Application for a non-material amendment following a grant of planning permission.
Town and Country Planning Act 1990

Proposed 4 dwellings

H22-1061-17

| Revision                                                                              | Date                                                                                        | Drawn     | Description |
|---------------------------------------------------------------------------------------|---------------------------------------------------------------------------------------------|-----------|-------------|
| Drawing                                                                               | Non Material Amendment (Change of roof, bedroom 5 window head & boundary treatment, Plot 3) |           |             |

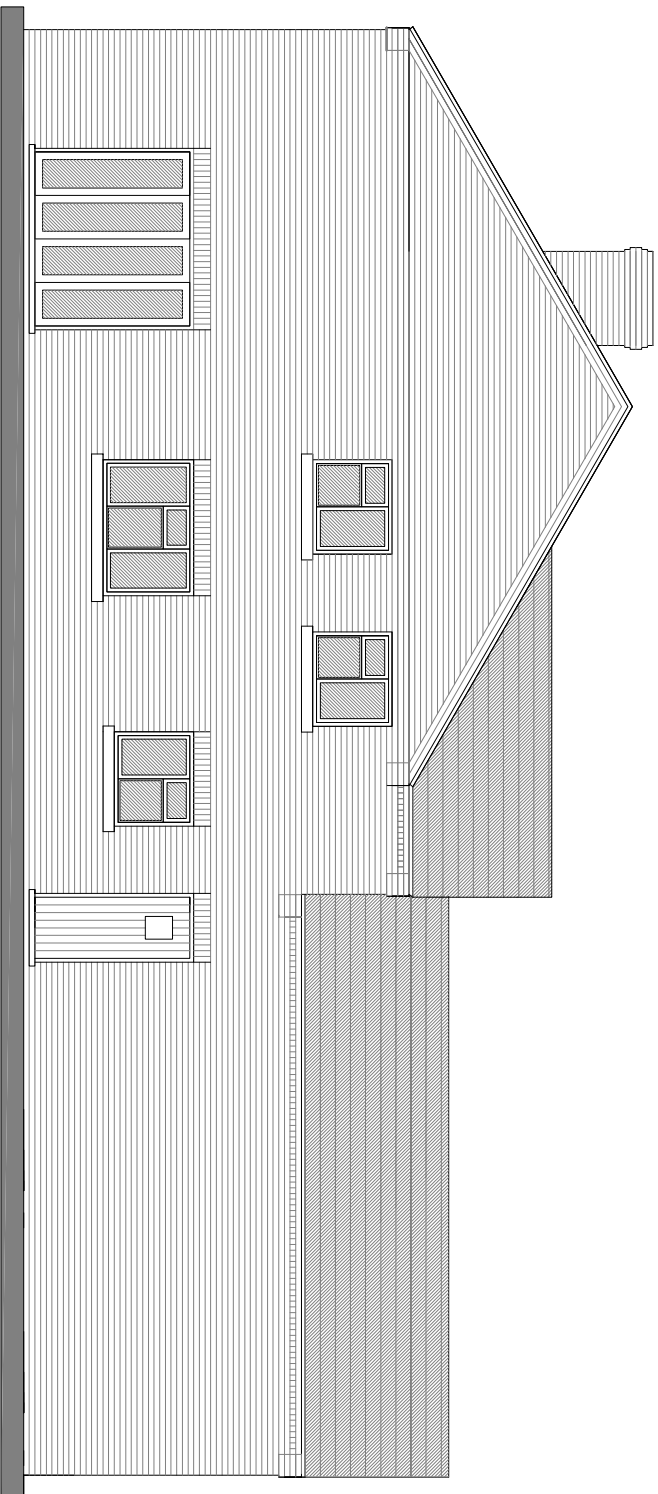
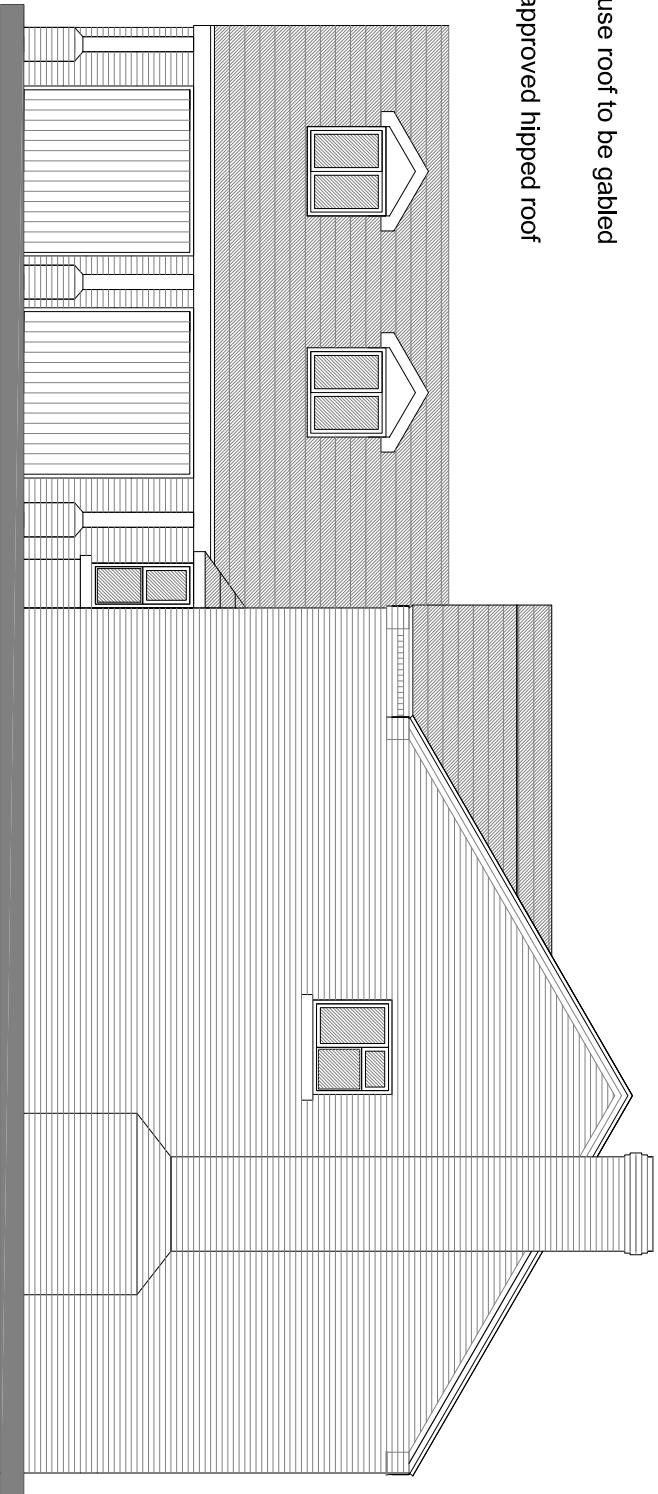
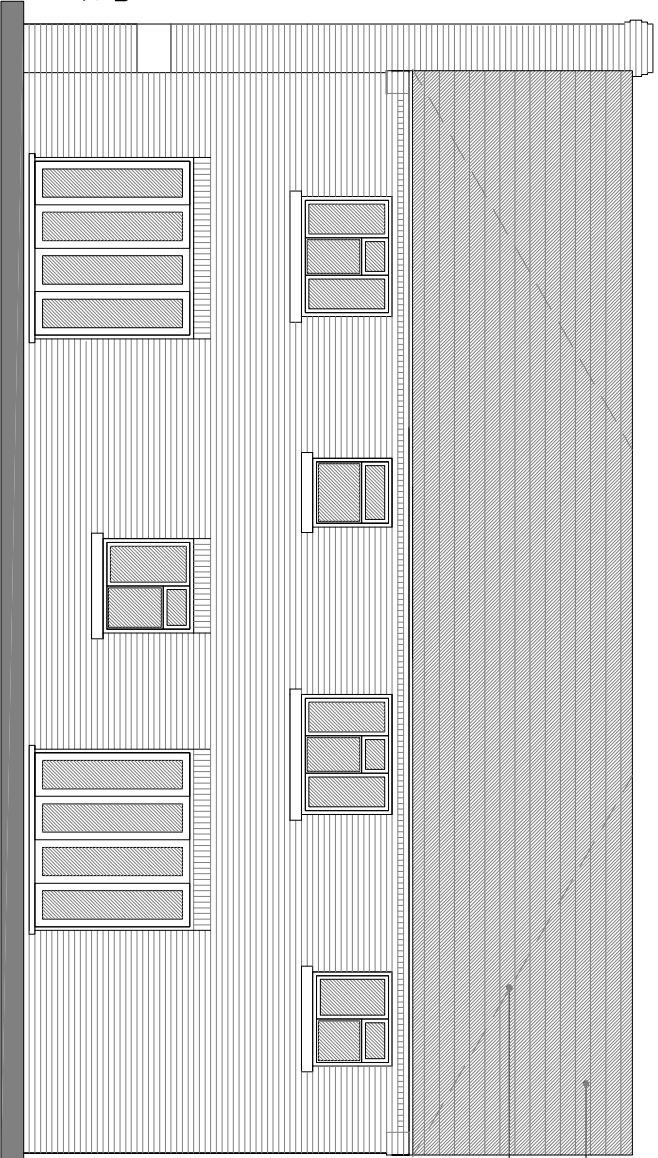
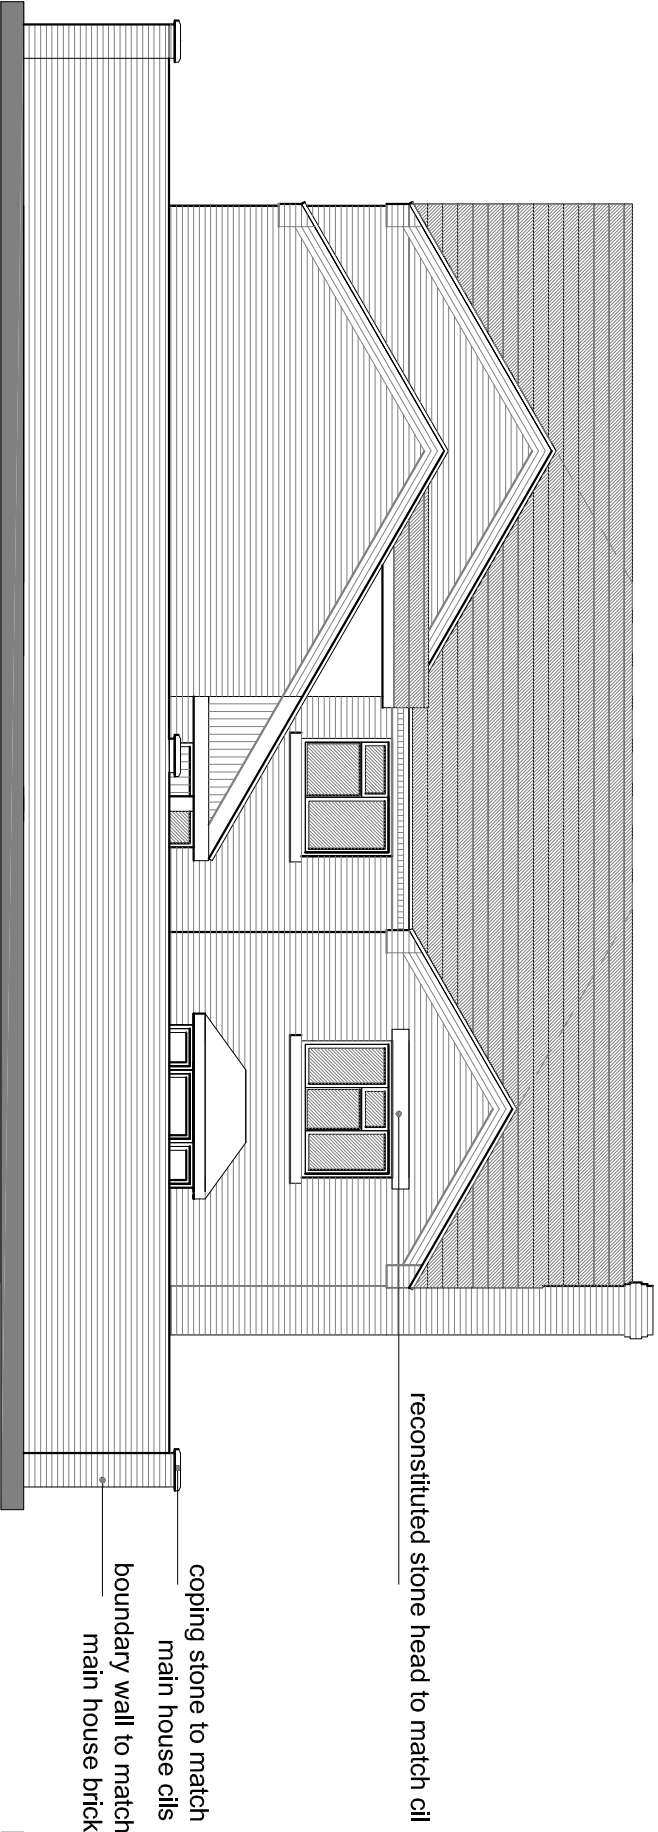
changing main roof from hipped to gabled

Boundary treatment
Window head to bedroom 5

In my opinion the proposed revisions (removal of hips on plot 3 and addition of boundary wall on boundary between plots 3 and 4) can be dealt with by means of a non-material amendment.
